# CITY OF ALBUQUERQUE

**Re: ABQ Bio-park Insectarium**  
**No Address**  
**Request for Permanent C.O. – Not Accepted**  
**Engineer's Stamp dated: 12-10-13 (J12D014A)**  
**Certification dated: 5-12-15**

C-101

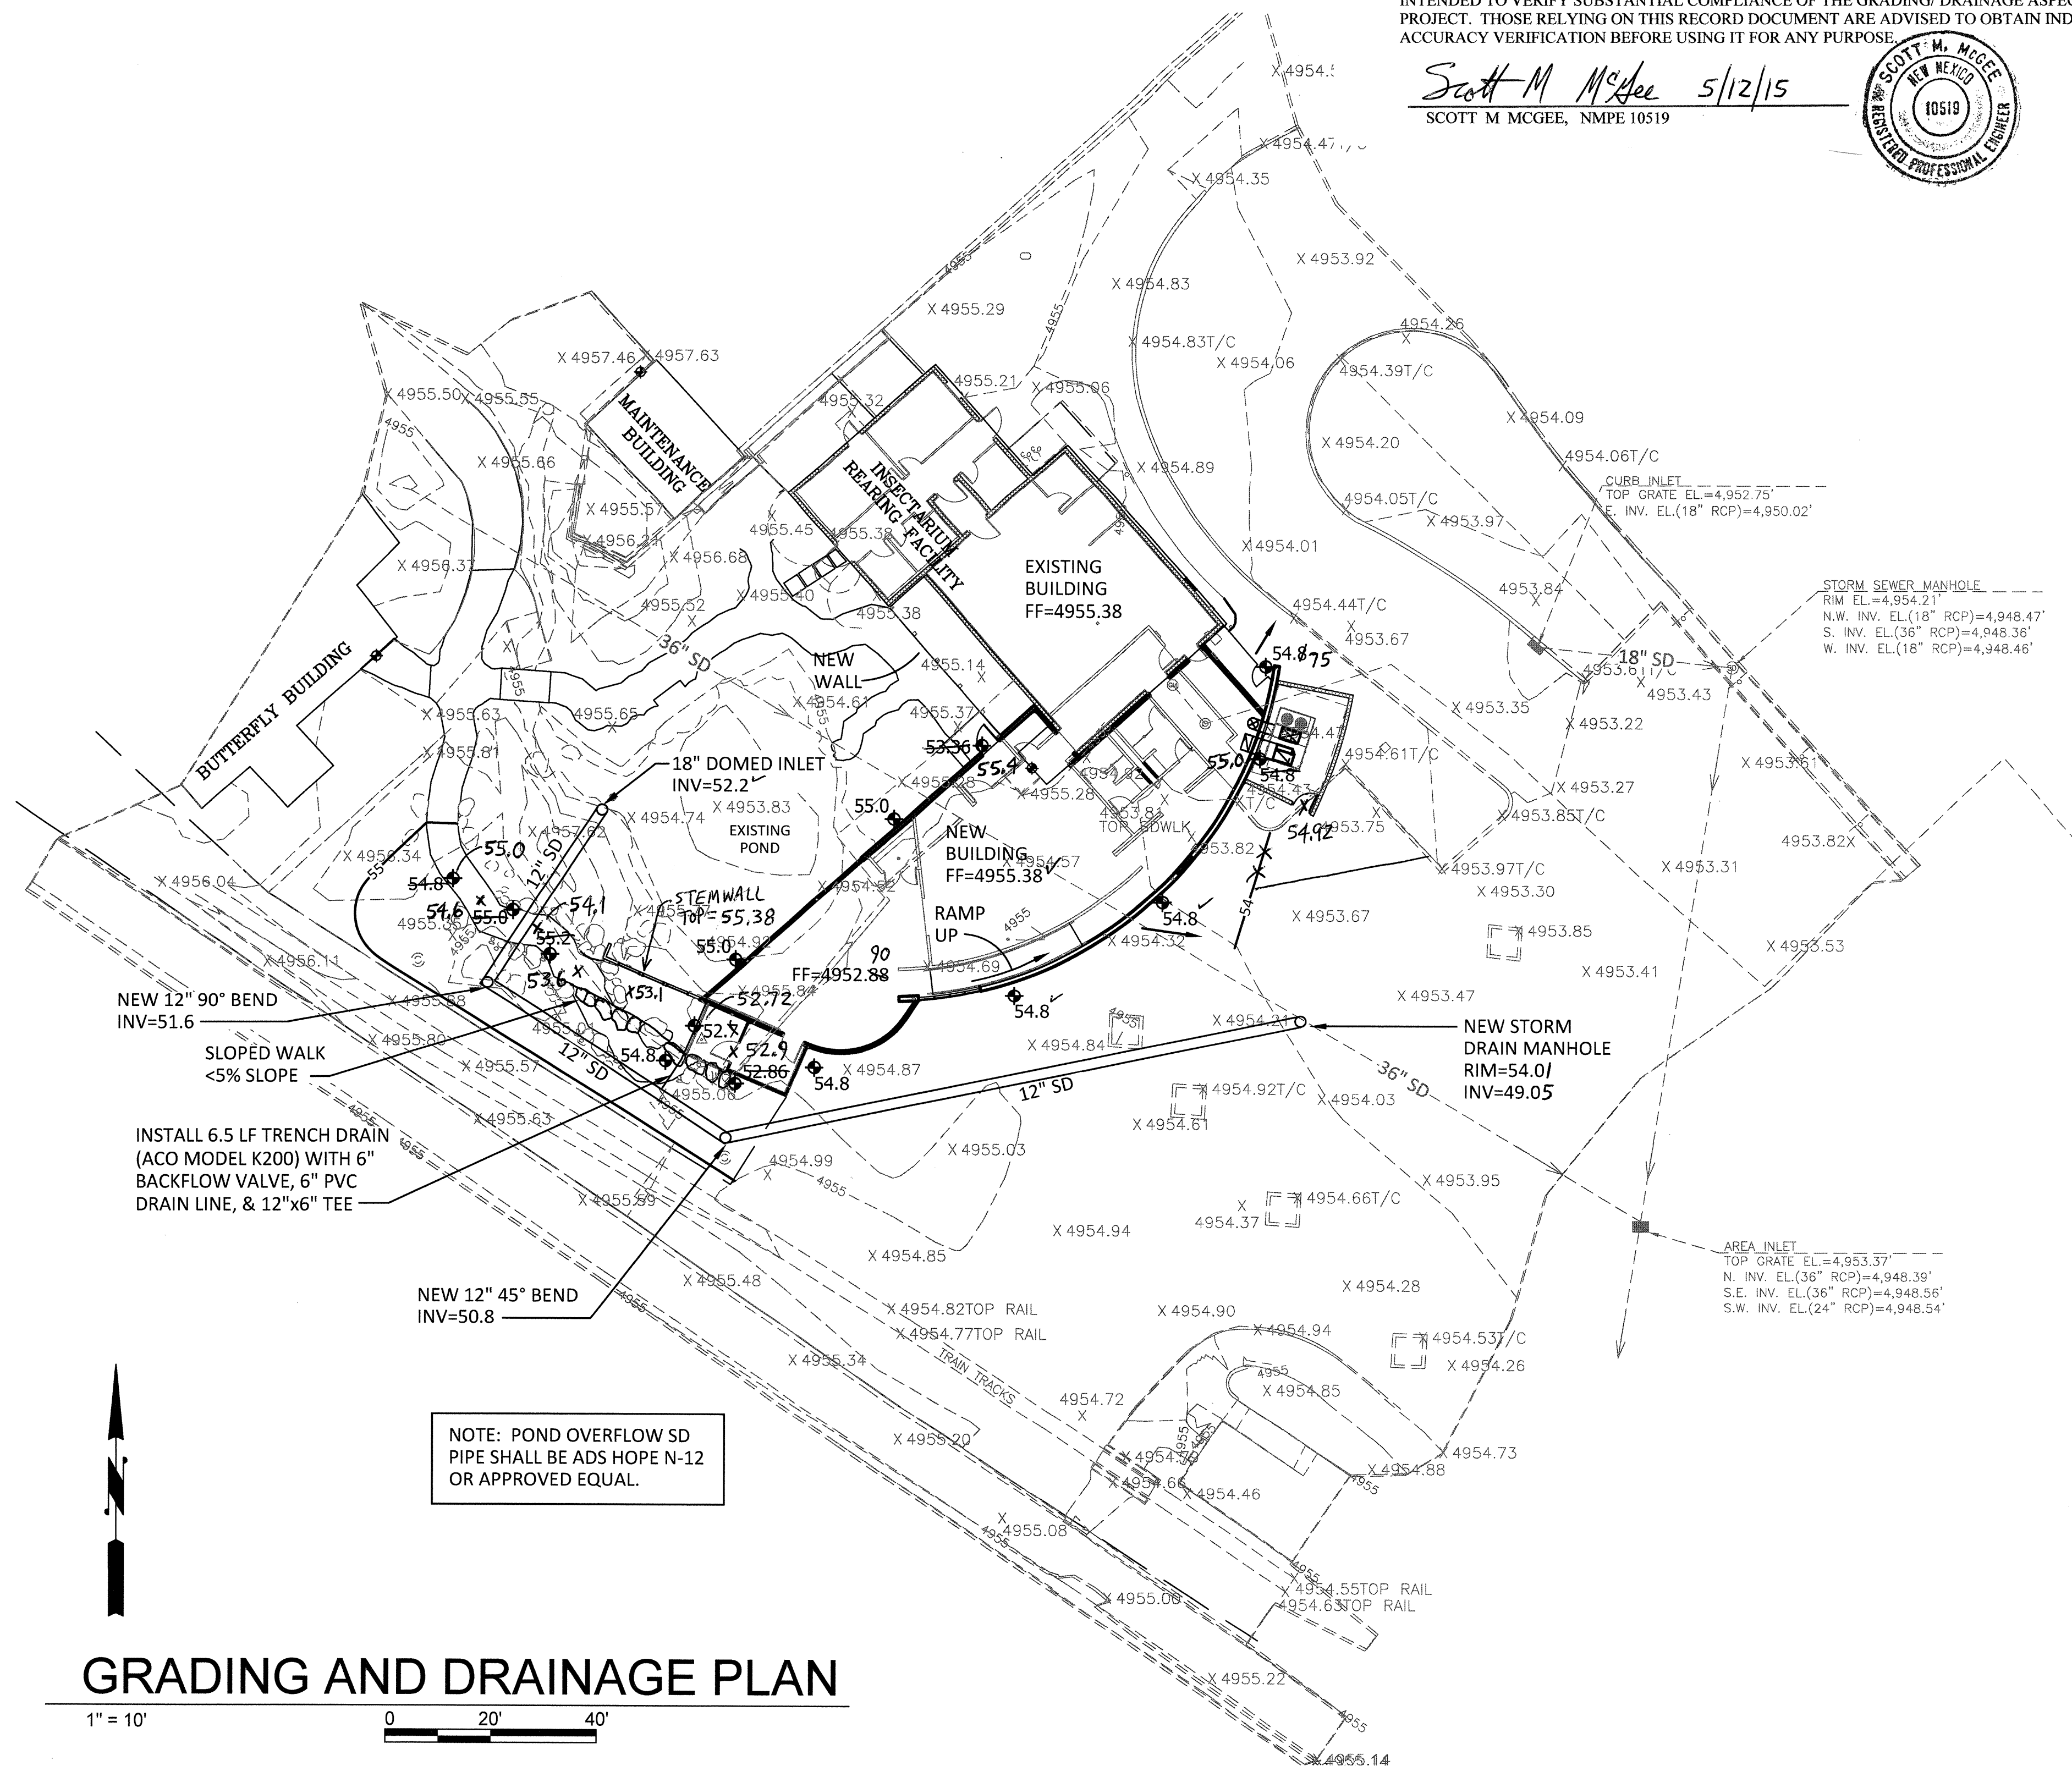
Based on the Certification received on 5/12/2015, the Insectarium is not acceptable for release of Certificate of Occupancy by Hydrology. Construction fencing was surrounding the site, numerous flooding problems and several piles of dirt and debris were existing.
